**RE: SUBMISSION TO PARRAMATTA METRO OVER STATION DEVELOPMENT
(SSD-35538829)**

School Infrastructure New South Wales (SINSW), on behalf of the Department of Education (DoE), welcomes the opportunity to provide comments on Concept State Significant Development Application (Concept SSDA) SSD-35538829 for the Parramatta Metro Over Station Development within the block bound by George Street, Church Street, Smith Street and Macquarie Street (the site).

6.6 Key Destinations Use Hubs

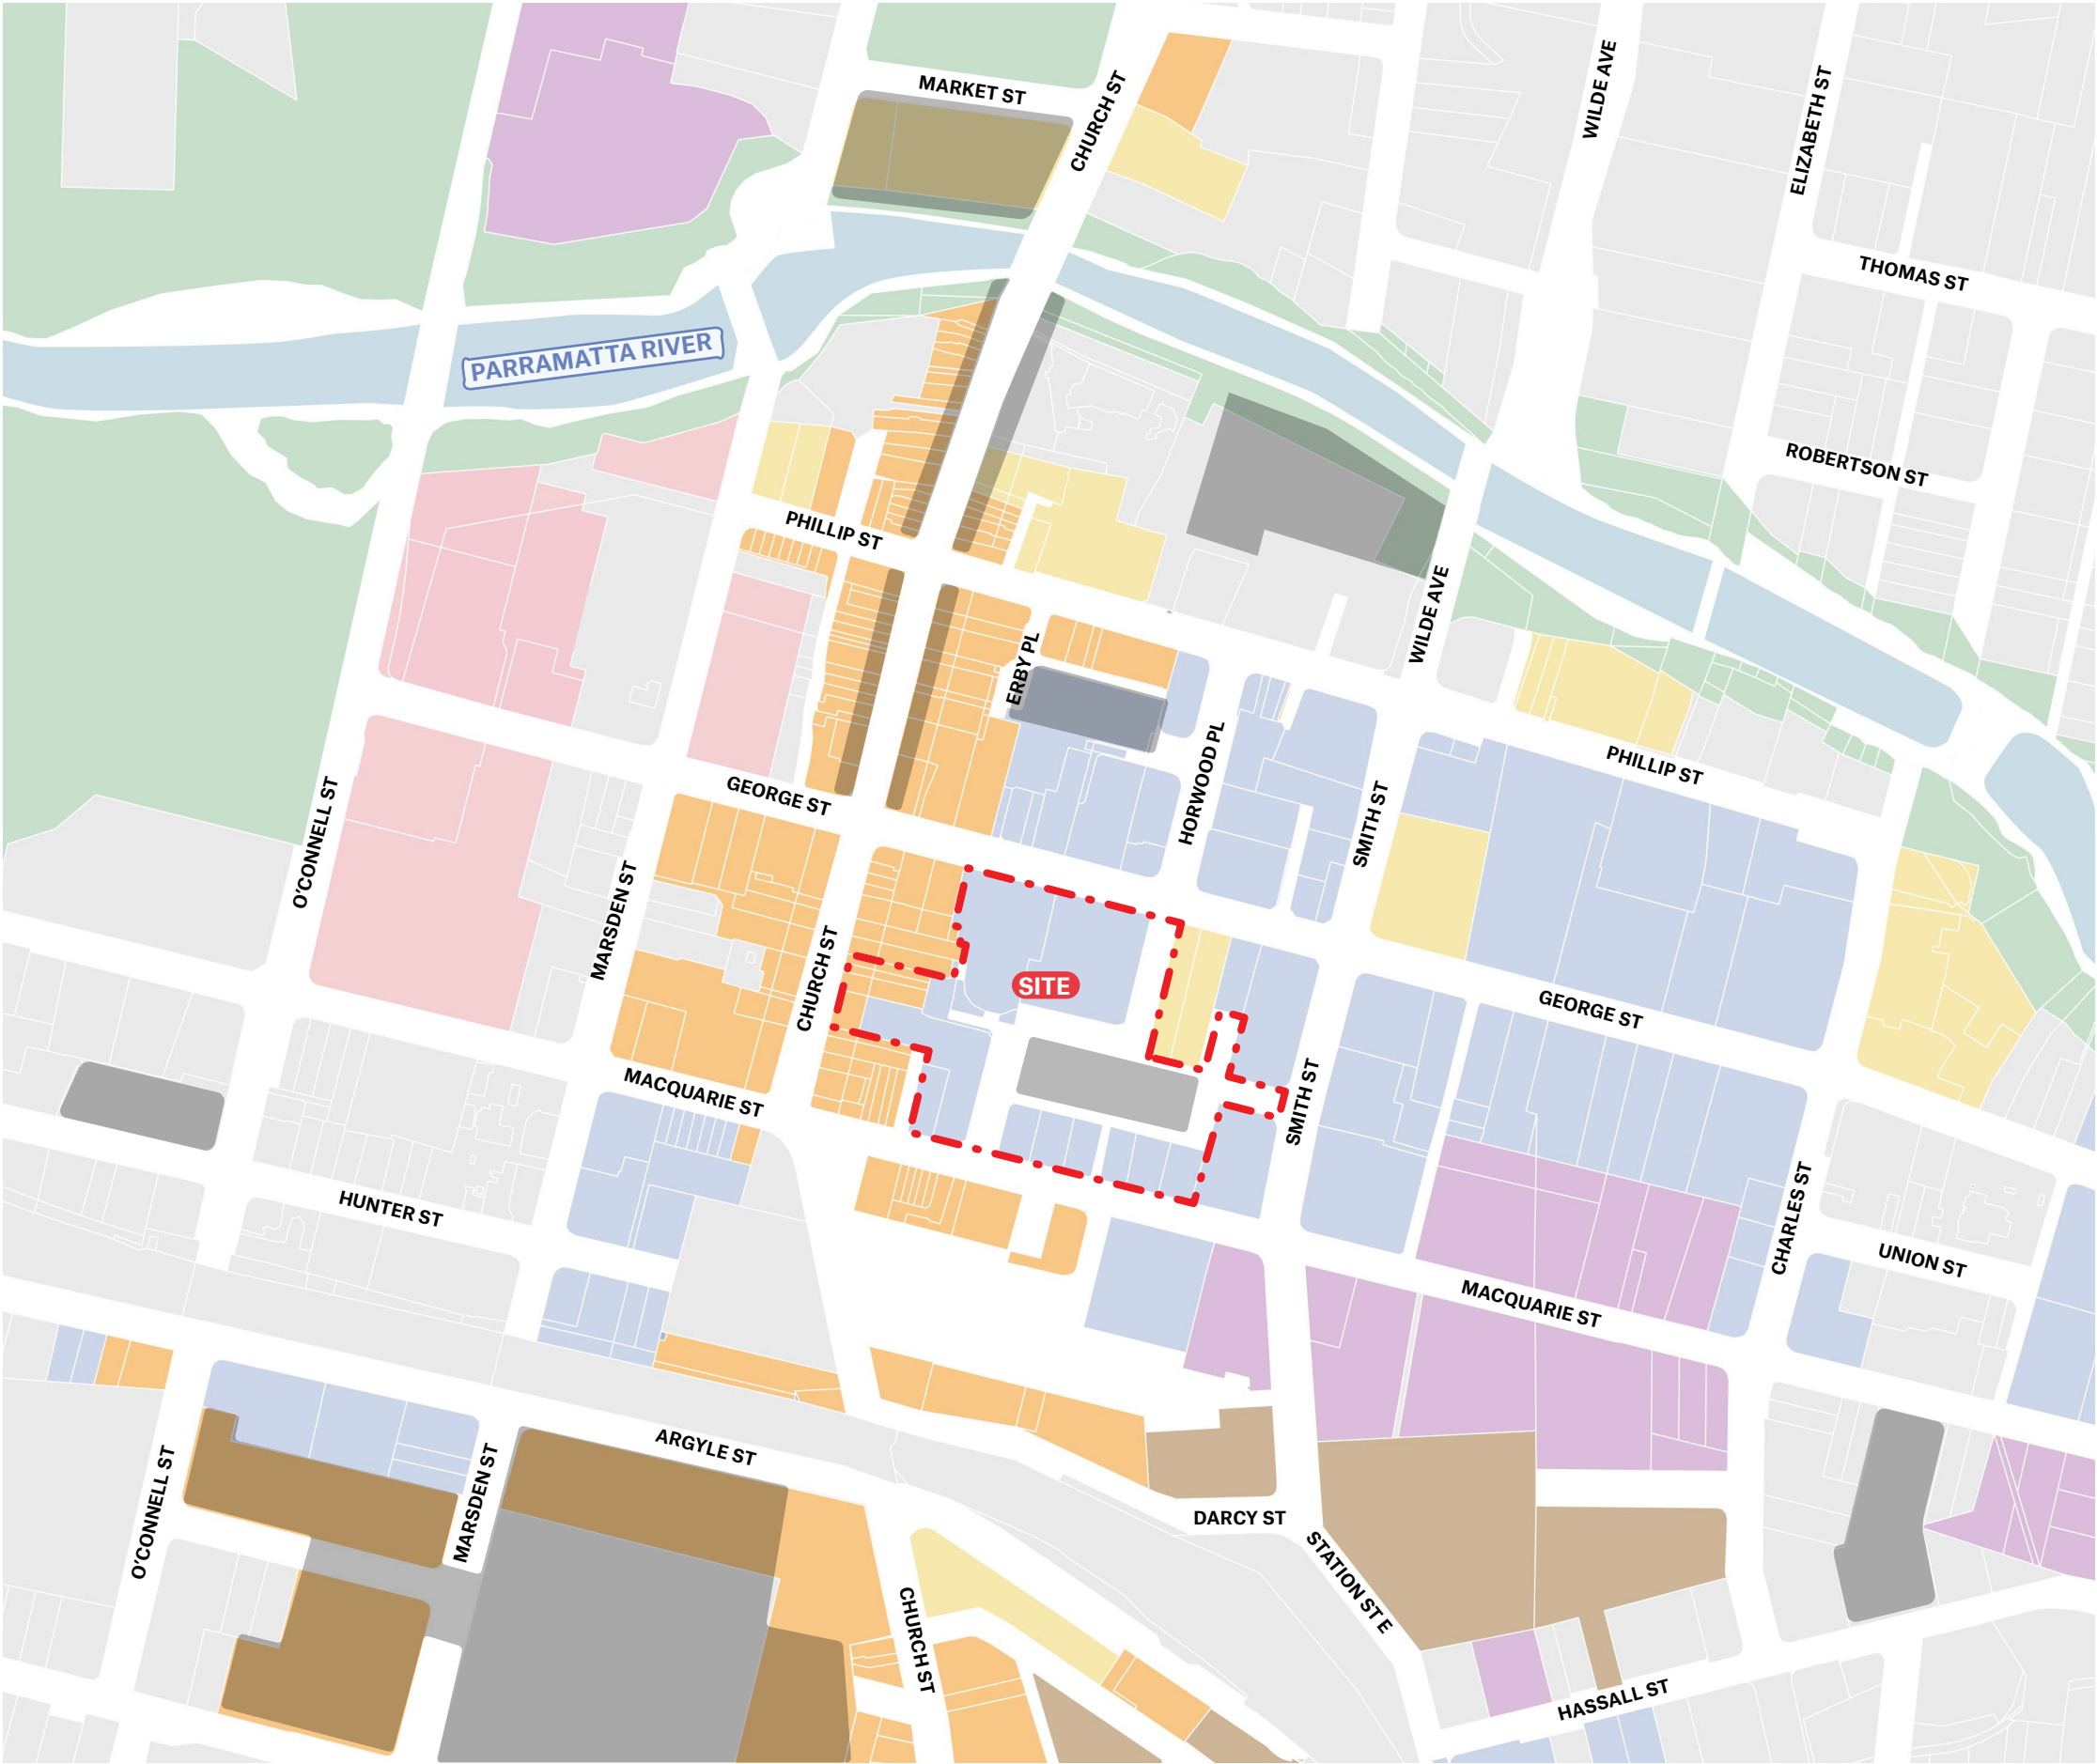
Figure 2-4 within the EIS annotates surrounding development that is considered a major attractor and includes Arthur Phillip High School and Parramatta Public School. However, the boundaries of the school shown on Figure 2-4 do not accurately reflect the current school boundaries as shown below.
